Firethorn Application Ref. 21/01630/OUT – Update, 30 March 2022

Executive Summary

Section A: New Points from Firethorn Response TN007 April 2022

Drawing file: 4600-1100-T-060-A - A4095 Howes Lane - Bucknell Road - Proposed Junction - General Arrangement Measurements.dwg Date: Mar 15, 2022 - 12:20pm

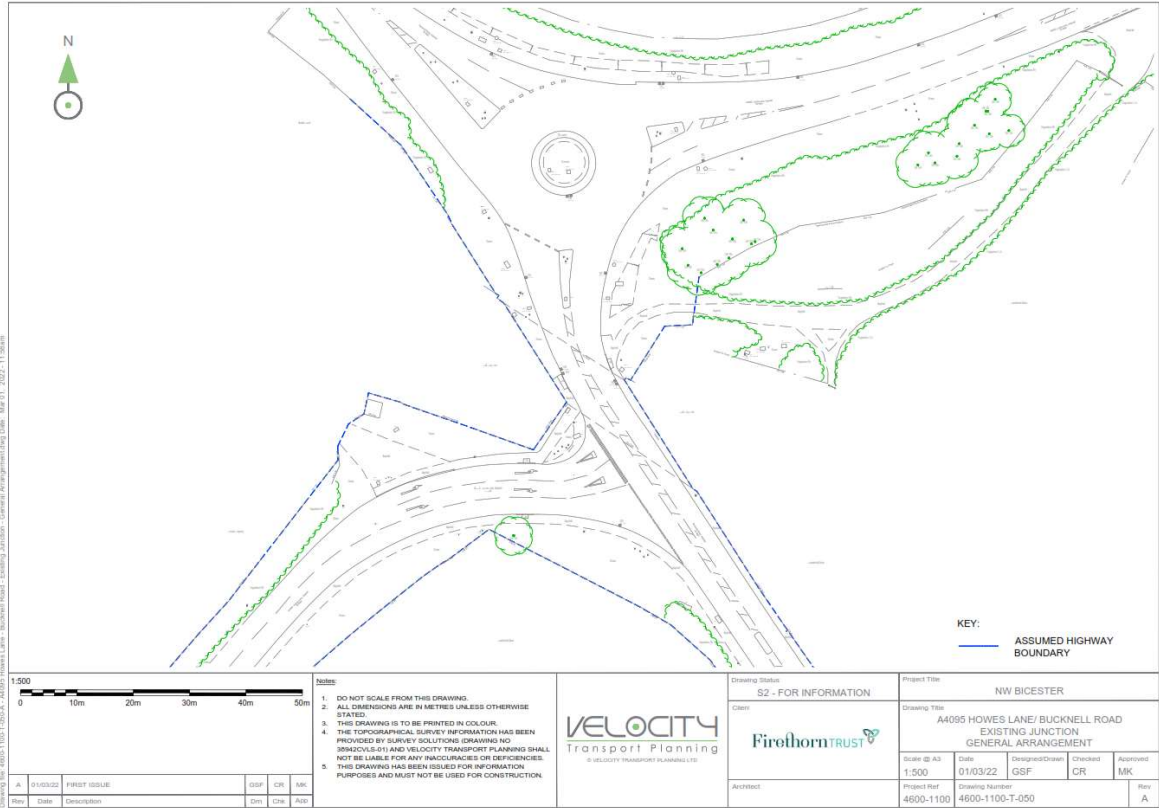
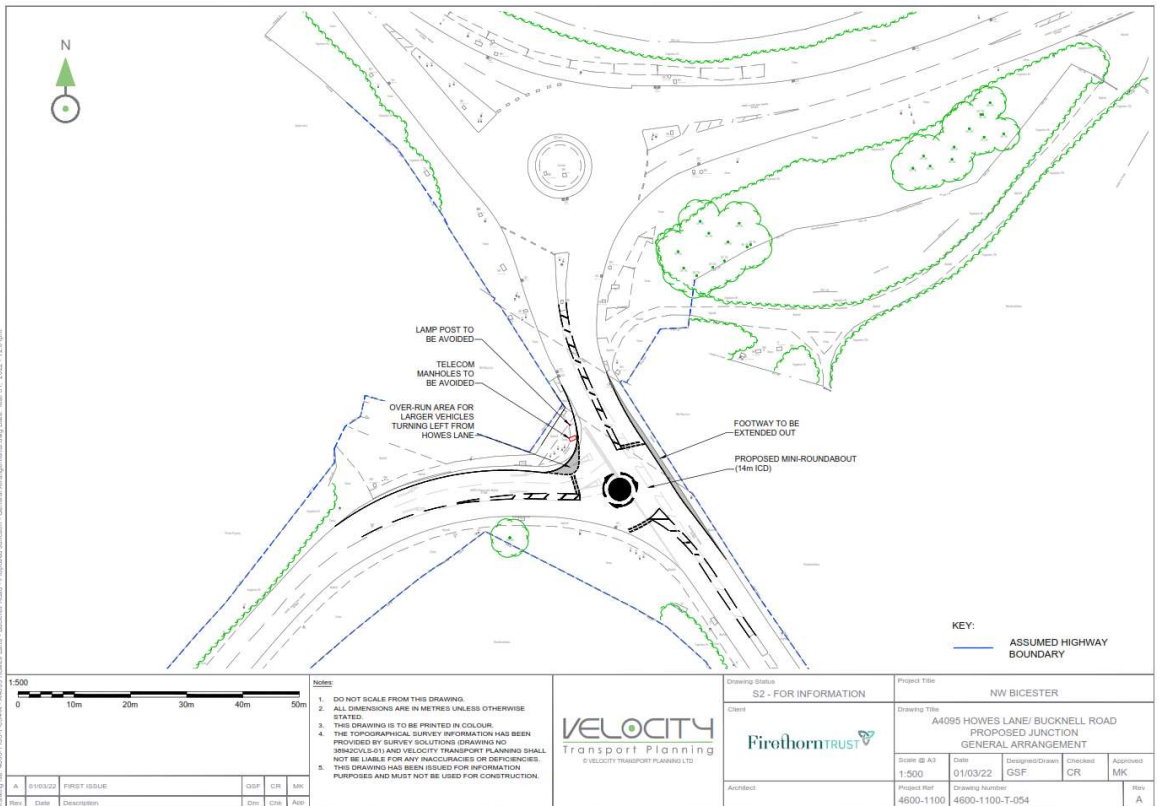
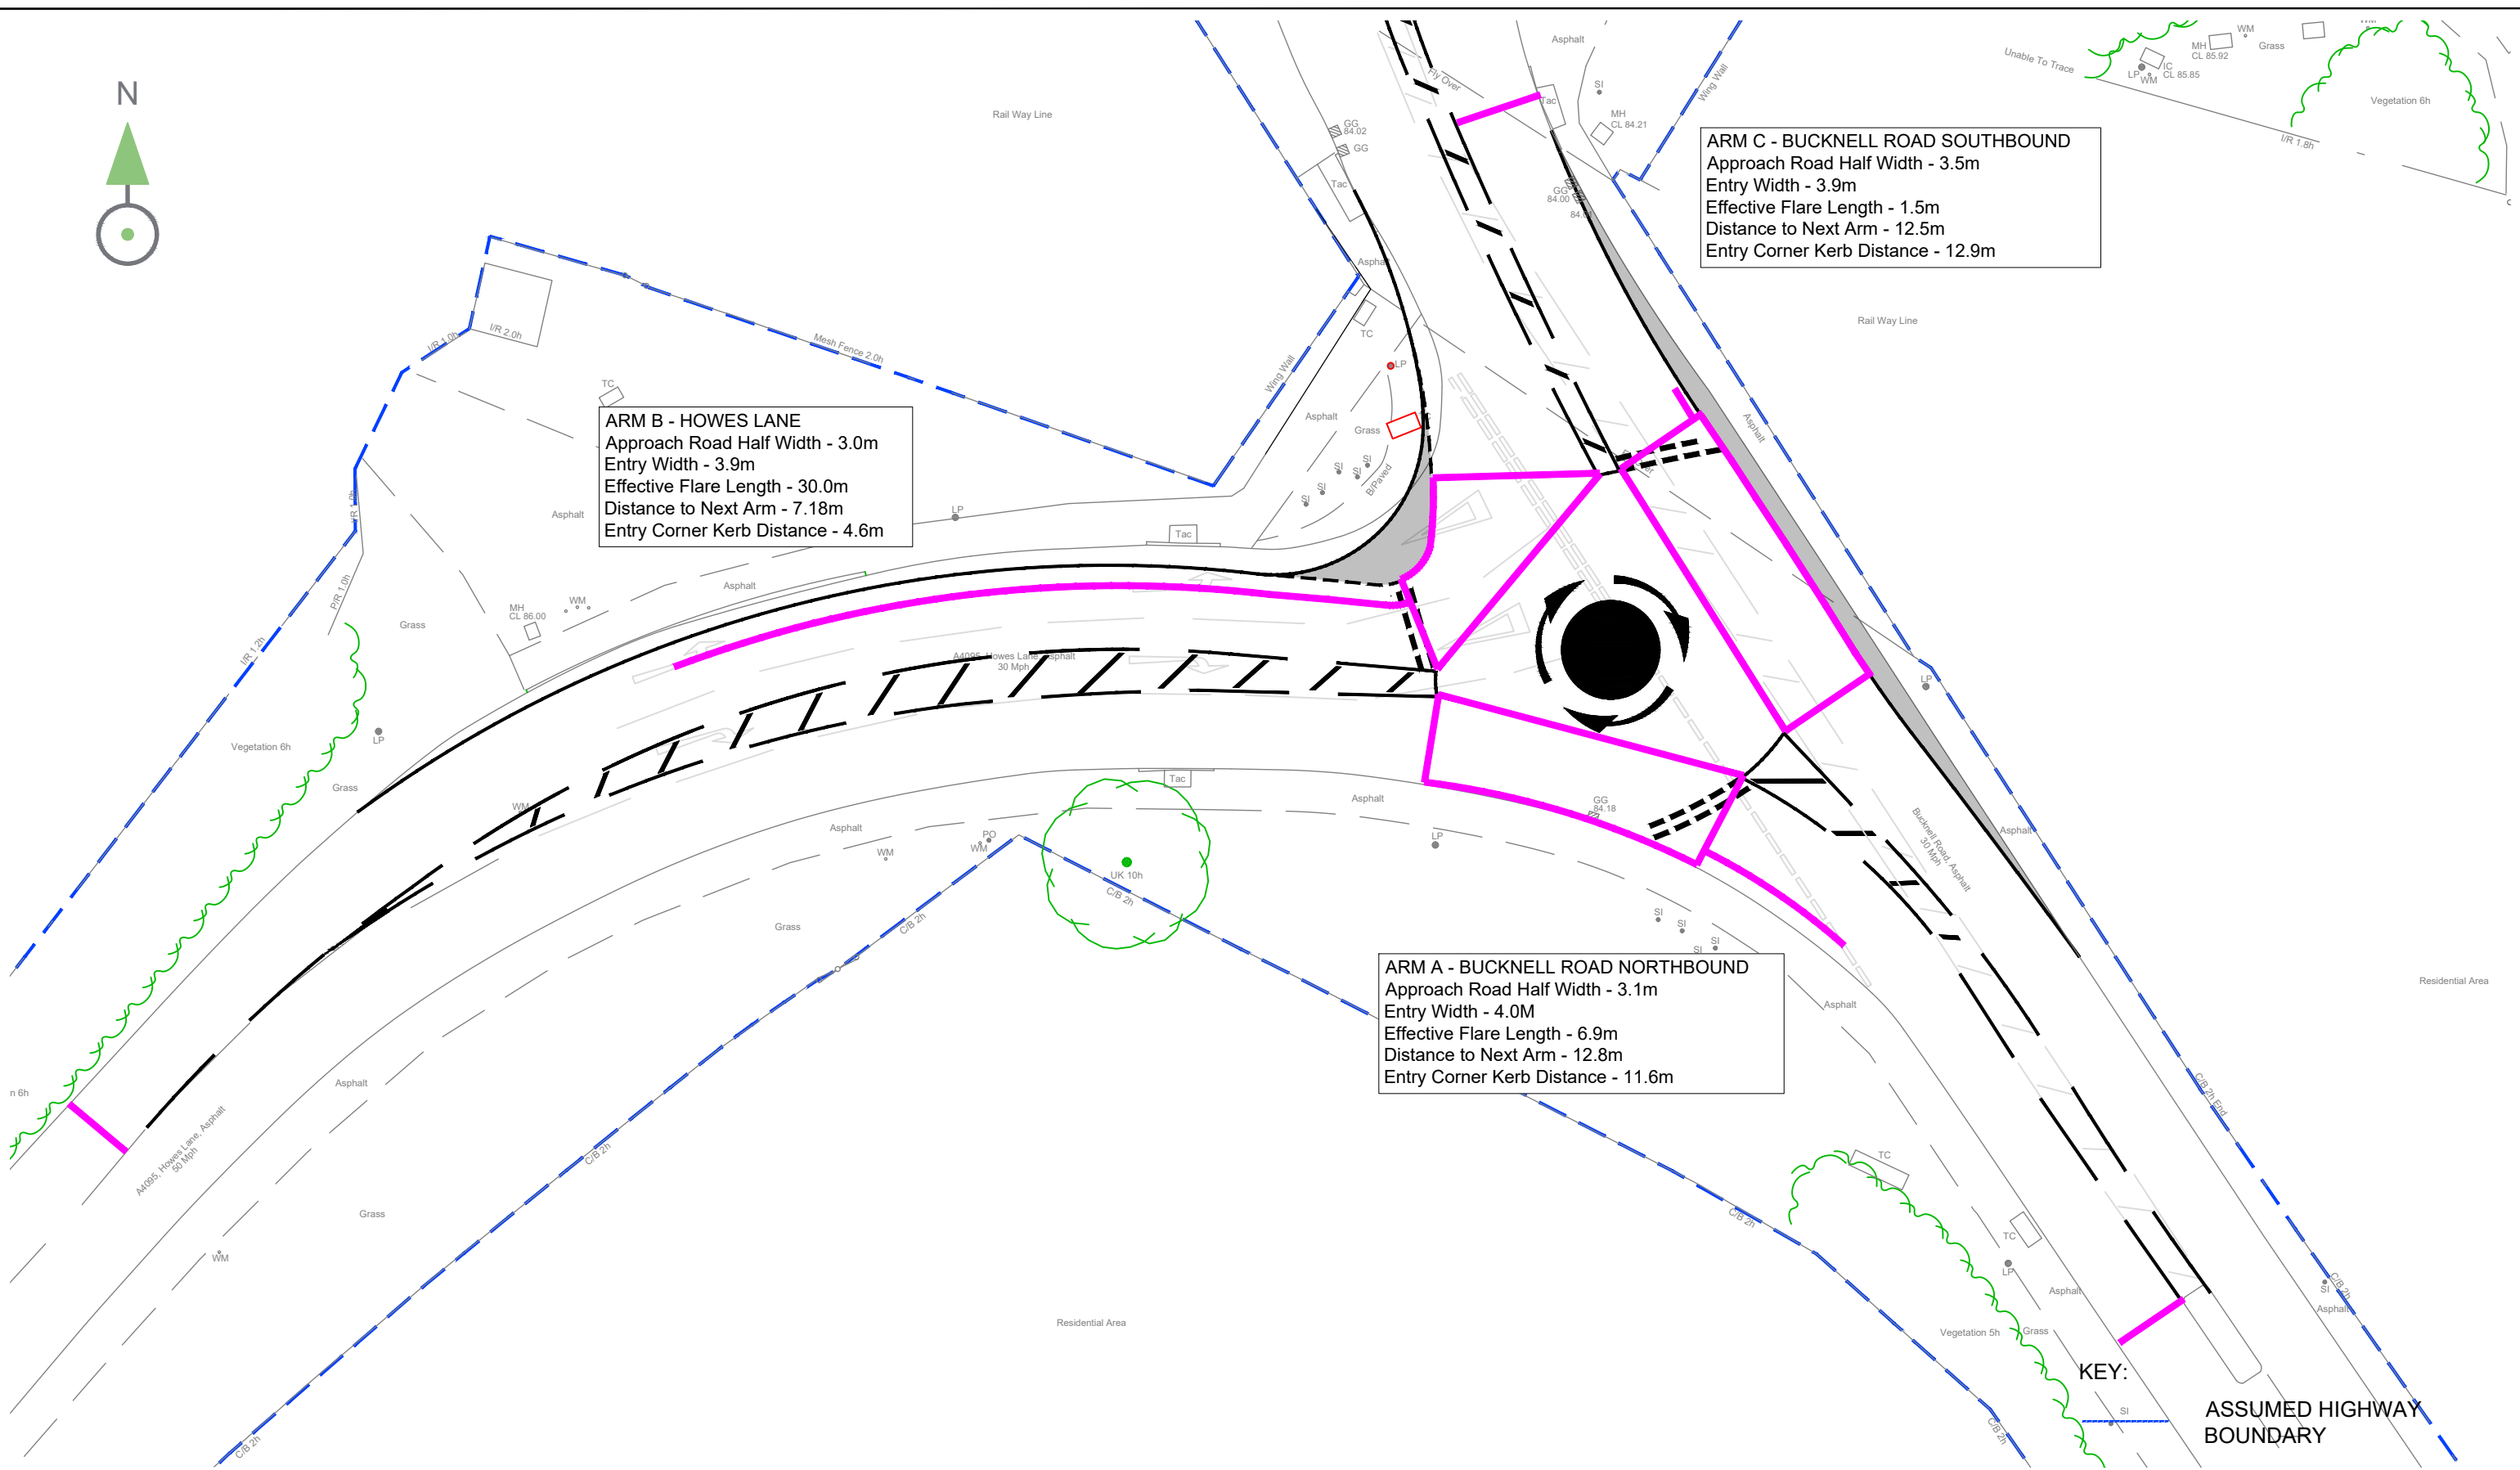
Table 3-1 of TN006 shows that, even with the proposed short-term solution, over the AM and PM peak hours, 6 of the 12 junction flows analysed (i.e. half) are significantly in excess of RFC of 0.85, with 4 of these greater than 1.25; there are also 3 between 0.82-0.84. However, the impact of the 530 Firethorn homes has been studied *in isolation from* all concurrent developments, especially Hawkwell Village – so none of the *interaction effects* are contained; and these are likely also be very significant. The *combination* must be modelled together, to get accurate results.

The conclusion made is that “the proposed interim improvement scheme in the form of a mini-roundabout associated with the Proposed Development provides a material improvement on the A4095 Howes Lane using the severity thresholds previously identified by OCC.”

DRAWING TITLE
**ELMSBROOK SPINE
ROAD ASSESSMENT**

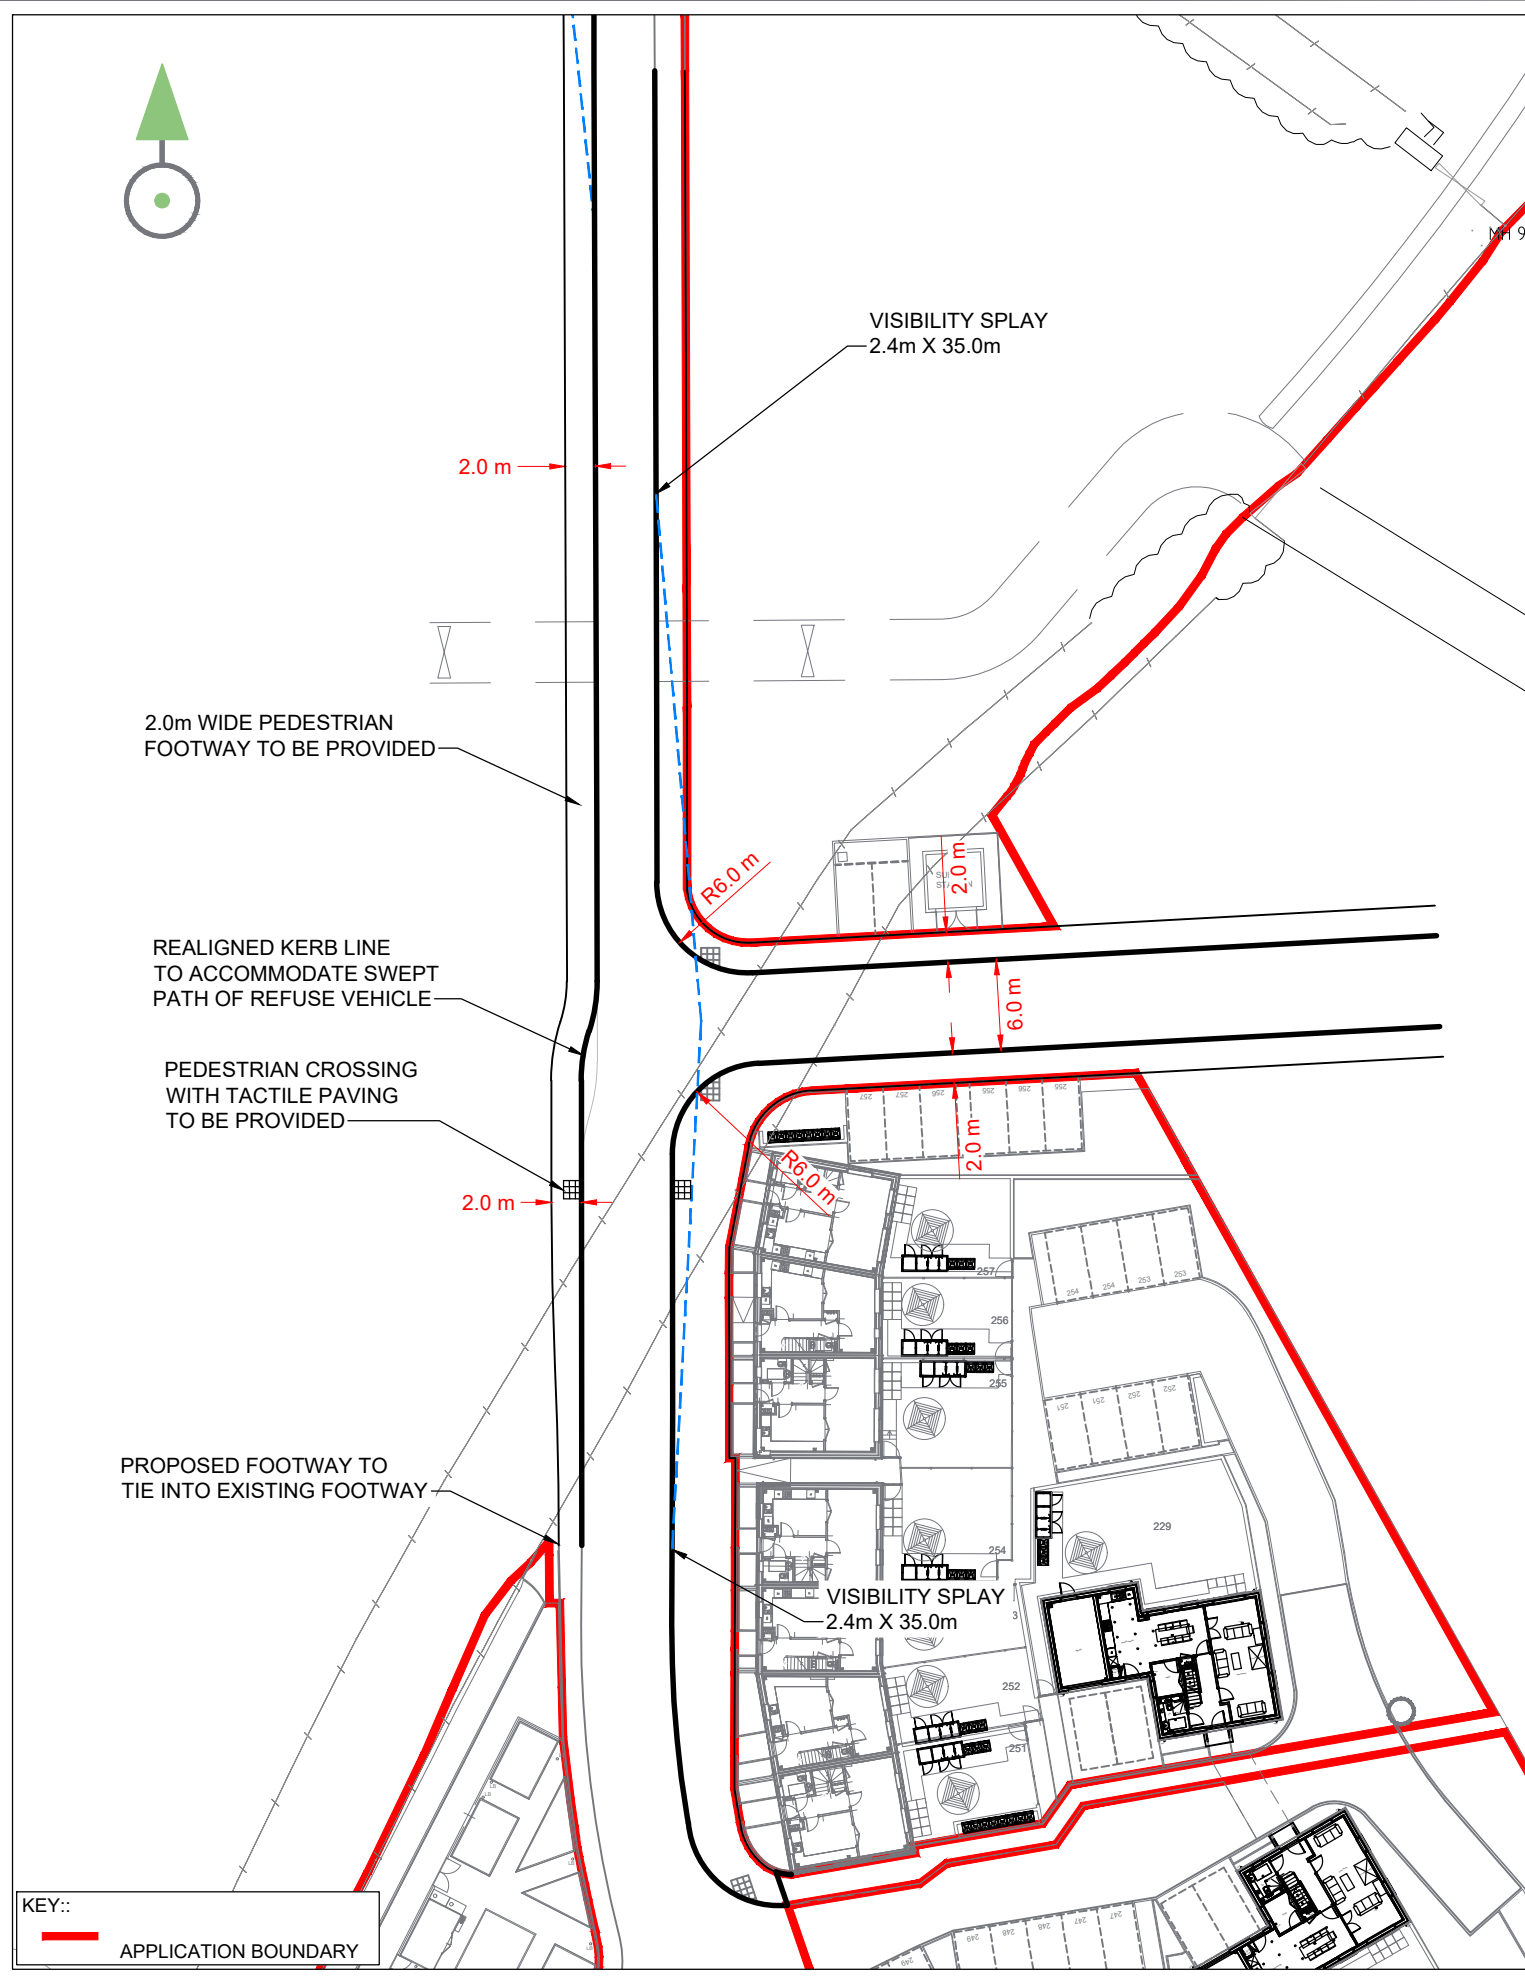
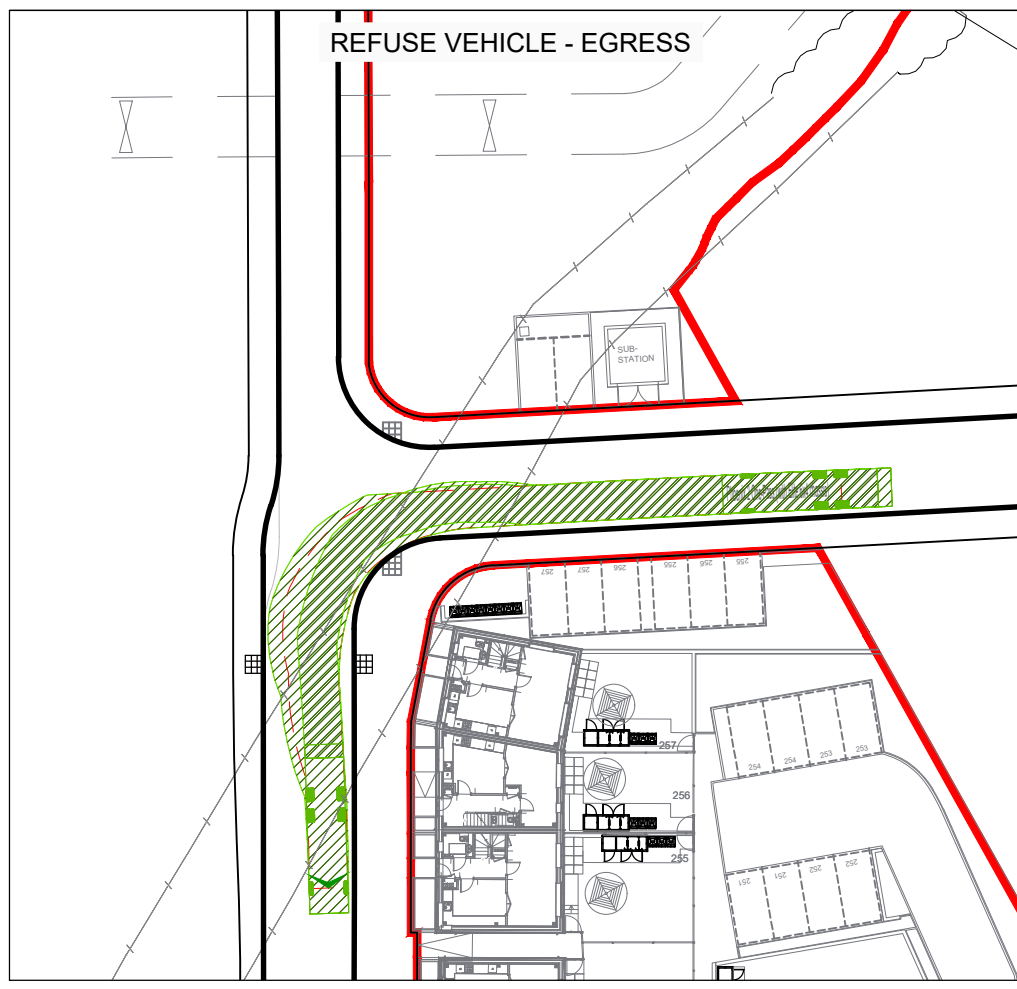
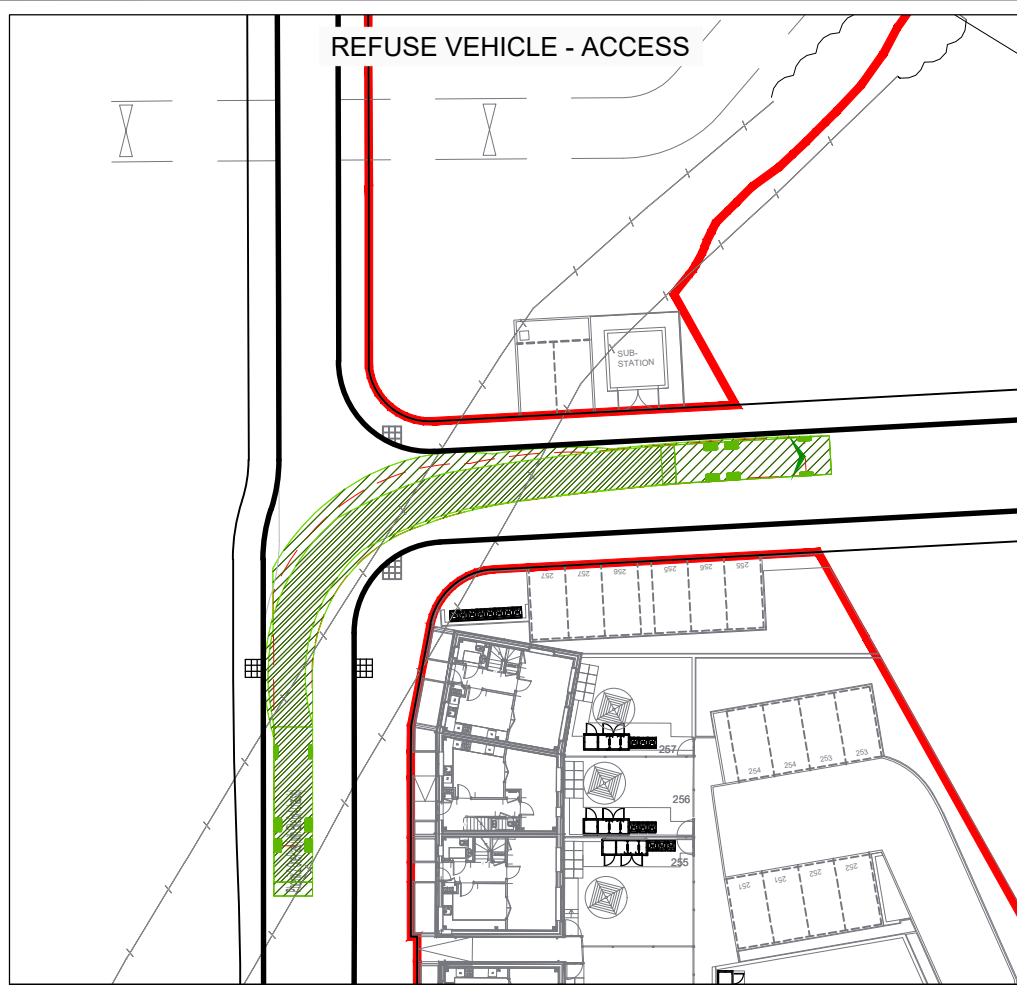
Please note also: that the reference ‘Elmsbrook Spine Road Assessment’ drawing, ref. # 4600 / 1100 – T – 070, included in ‘Appendix B – VTP Drawings’ – actually shows that **the wrong section of Charlotte Avenue has been assessed** – the drawing only shows Charlotte Avenue from North of the junction with Cranberry Avenue, outside Gagle Brook School – whereas the ‘Phase 1/2 Park 2x bottlenecks’ we have previously referred to and described in detail are on Charlotte Avenue to the East-South-East of that junction, i.e. off the map, and not assessed.
